Subject: 22/01653/F Land South Of The Old Council Houses Opposite Brook Cottage, Wroxton Lane, Horley, OX15 6BB

Description: Proposed village parking area for 8 vehicles to relieve on-street parking issues, with new footbridge over stream and footpath formed along Wroxton Lane

Oxfordshire County Council, as the Local Highways Authority, notify the District Planning Authority that they **object** to the granting of planning permission.

POST & RAIL FENCE ELEVATION

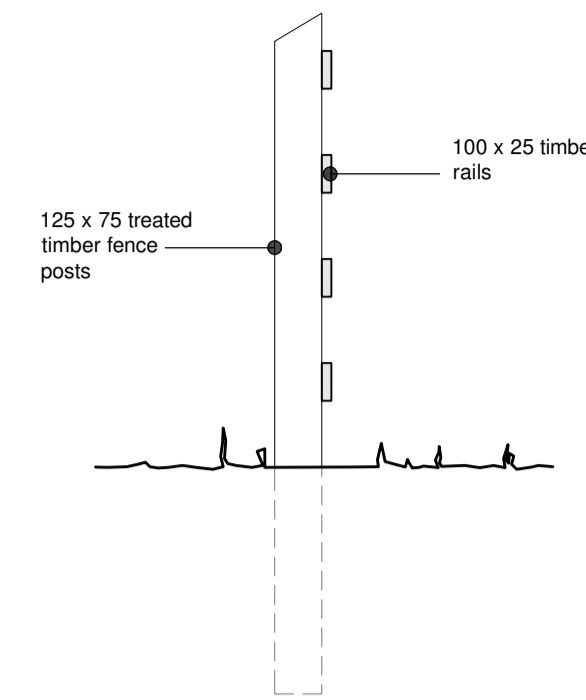
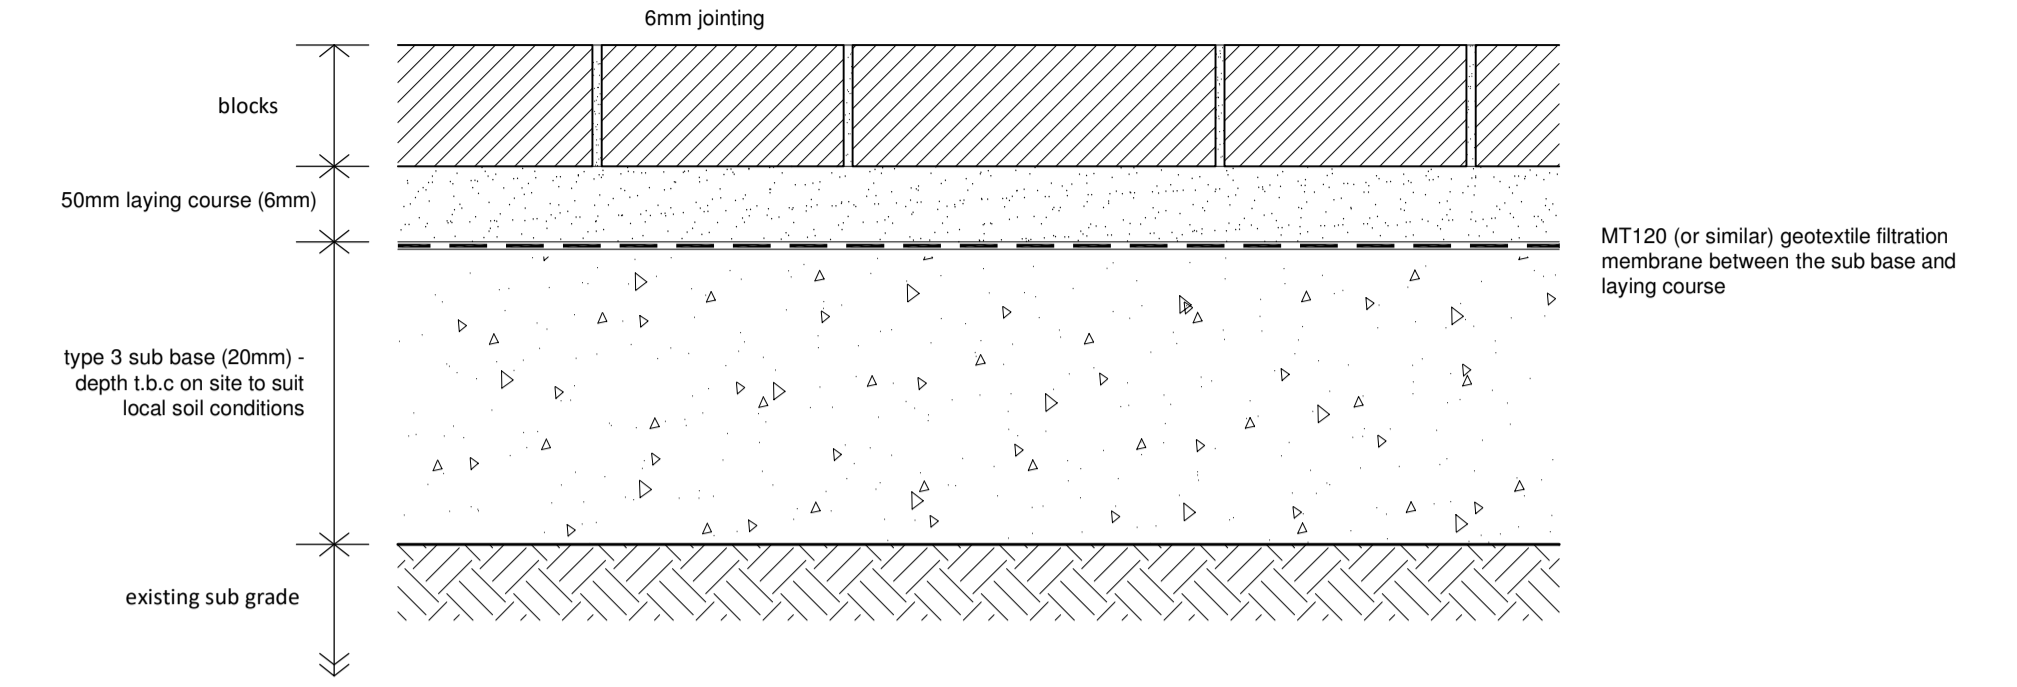
The Oxfordshire Street Design Guide outlines that if constrained along one edge then the width of a vehicle space should increase to 2.7m. With the implementation of the fence, the two 'end' vehicle spaces should increase to 2.7m in width from 2.5m for accessibility.
